My comments - on the Written Submission on behalf of PEA by Bidwells, 6 July 2026 “Note on the Applicant’s Response to PEA’s Heritage Rebuttal (REP4-369)”

8.4.12.2 Response to ISH2 Action Point 27 – Masterplans, Appendix E: Aldham, Fordham and Fordstreet

Title:
Action Point 27: Colne Valley (including Fordham, Ford Street, Aldham) - Draft Constraints Plan
 Page 2 of 2

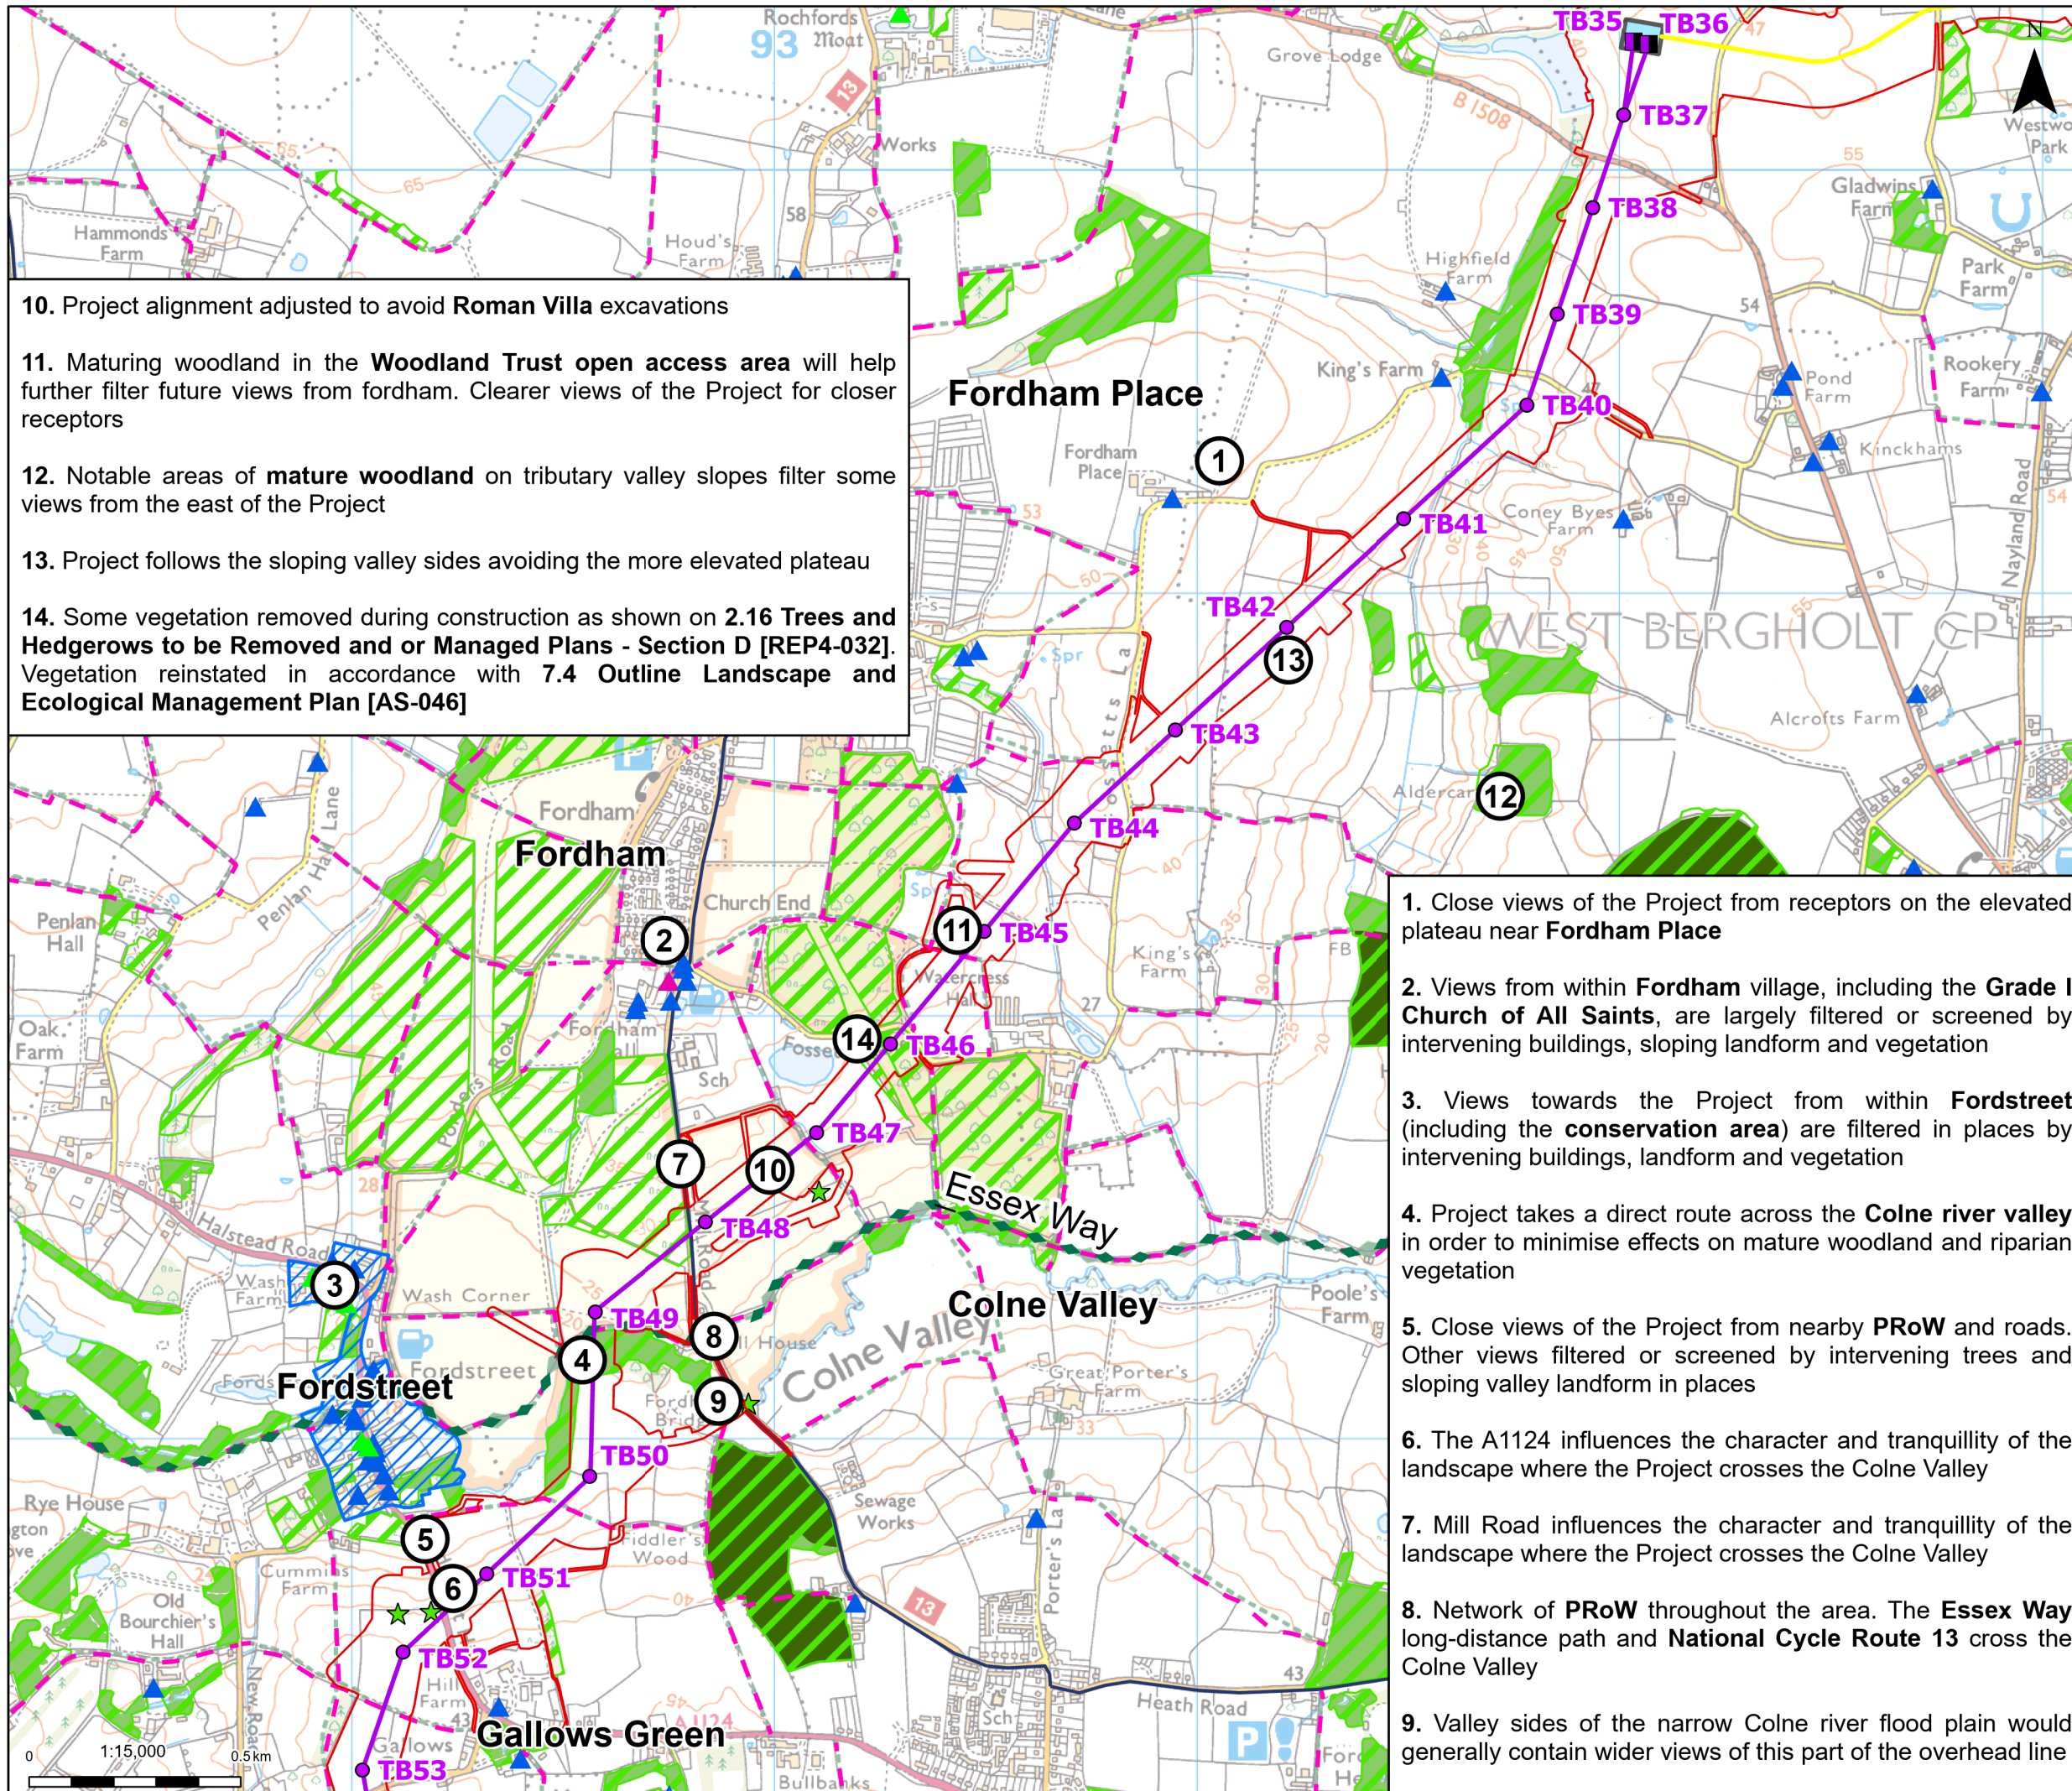
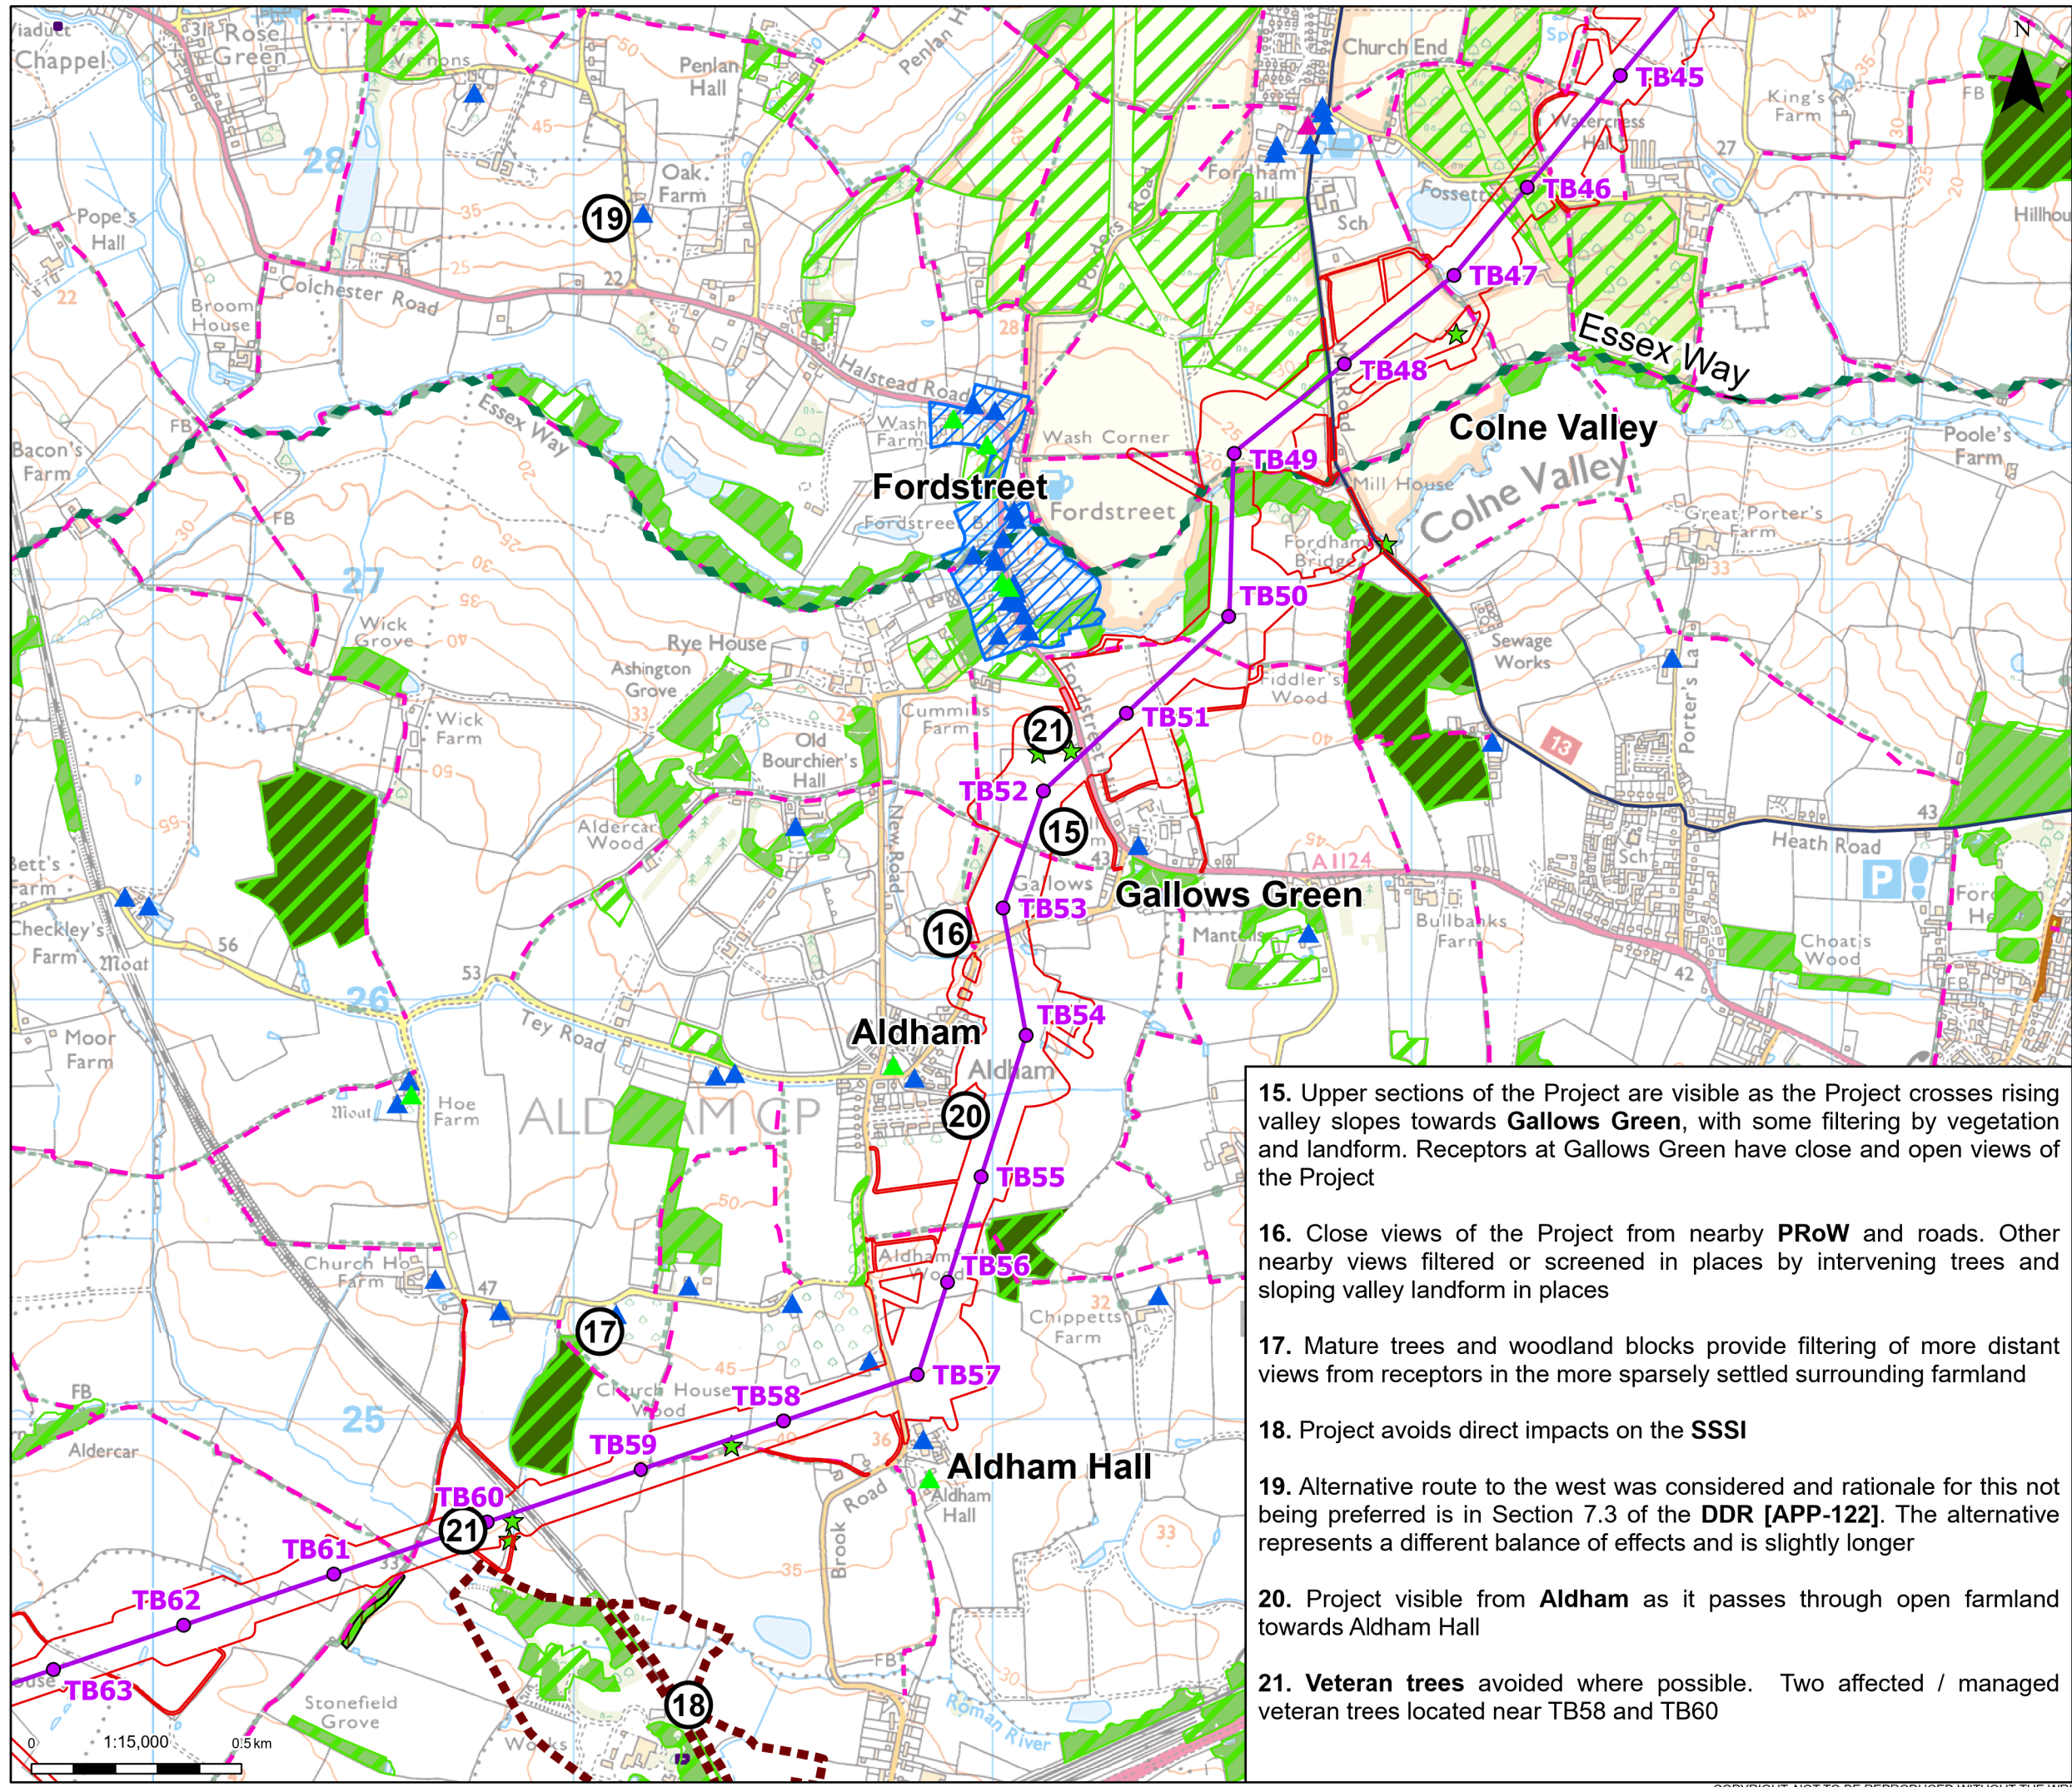
It is good that the ExA requested a response from NG, by D 6, regarding the closeness to Hines Close, and Church Grove, Aldham of Pylons TB54 and 55
